WELWYN HATFIELD BOROUGH COUNCIL – DEVELOPMENT MANAGEMENT
DELEGATED REPORT

APPLICATION No:	S6/2012/1775/FP
APPLICATION Site:	63 The Ridgeway, Cuffley

The proposed development applies for the retention of front boundary wall, railings and gates, which enclose the frontage of the plot. The Design and Access Statement notes that the gates have a height of 2.2m, the brick wall and railings have a height of 1.8m and the brick piers have a height of 1.9m.

Existing Elevation of Walls and Gates

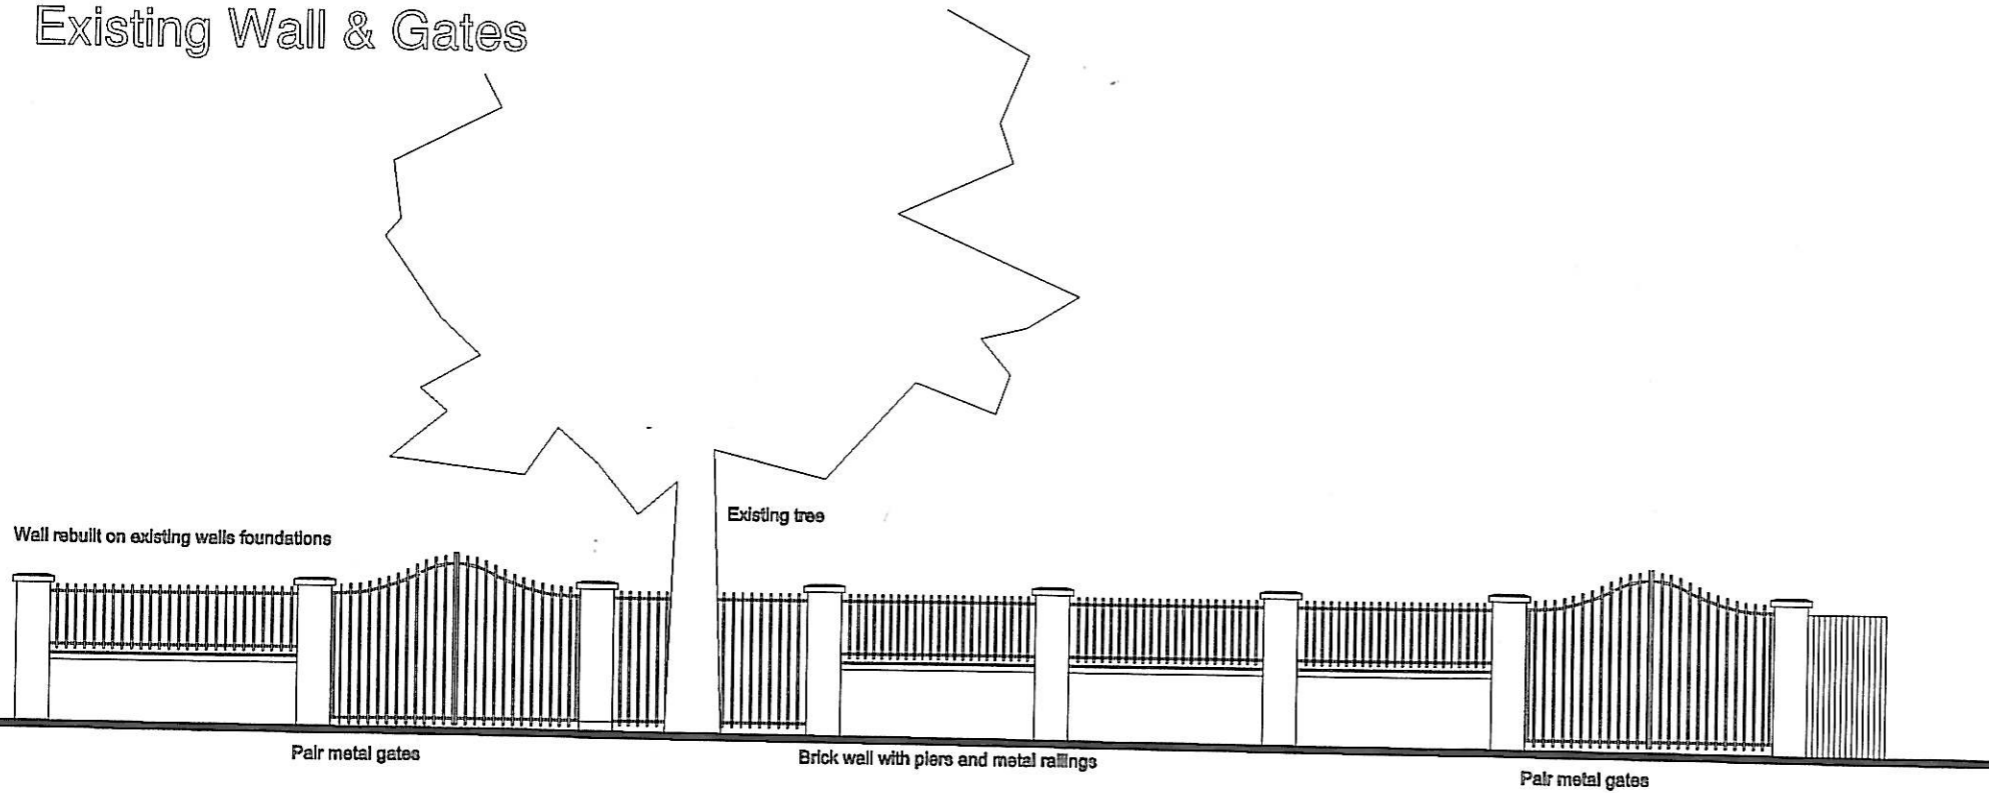
When considering the detailed design of the proposed boundary treatment, it has yellow bricks with a dark grey feature bricks. The main wall and pillars are particularly tall and the gates are excessively tall, which makes the whole development appear dominant and prominent. It has been acknowledged that the materials have been chosen to tie-in with the main dwelling; however, as the wall is to the front boundary of the plot and close the public footpath, the appearance of the brick is not offset and appears particularly prominent as it is a much brighter material than those which characterise the locality and the surrounding boundary treatments.

The application has been submitted with a statement which notes the development is comparable to front boundary treatments that are found at surrounding properties. The existing tall boundary treatments generally comprise very low dwarf walls with railings above. However, the proposal would have a relatively high wall with several pillars, which result in a more opaque and harsh boundary treatment which is

prominent and not appropriate for a rural area. This appearance affects the surrounding landscape and when viewed with the other development within the plot has an adverse impact upon the surrounding landscape. In general the properties within the locality are viewed with spacious gaps between the dwellings and soft landscaping can be seen in the distance between the gaps and to the frontage of the plots. However, the application site has a very manmade appearance with a substantial amount of hard landscaping, which affects the views of the surrounding landscape character area from the public view points to the front of the property. The proposal therefore conflicts with Policy RA10 and has an adverse impact upon the landscape character area that the site is within.

The applicant considers the proposal to be small scale and comparable examples are found within the locality. However, the proposal is significant in height and has a very substantial and urban appearance. When considering the height, design, colour and proximity to the public areas to the front of the plot, the proposal does not have a small scale or modest appearance. Furthermore, the proposal has a greater impact than the other front boundary treatments within the locality and these are not considered to characterise the surrounding area.

It has also been noted that the design and materials are compatible with the surrounding development. The proposed wall has been built from bright coloured and prominent bricks which do not harmonise with surroundings and are not appropriate for a rural setting. As detailed above the proposed boundary treatment is not in keeping with the character of the locality. The applicant's statement has also failed to recognise the differences in the individual type of boundary treatments and their impact upon the character of the area. Therefore, these factors are not

1. The proposed wall and railings have, by reason of its height, length, siting, materials, design and location, have an unnecessarily intrusive appearance out of keeping with and detrimental to the character of this rural Green Belt setting. Therefore, the proposal is contrary to The National Planning Policy Framework and the Welwyn Hatfield District Plan Policies RA3, RA10, D1 and D2 of the Welwyn Hatfield District Plan 2005 and the Supplementary Design Guidance (Statement of Council Policy).
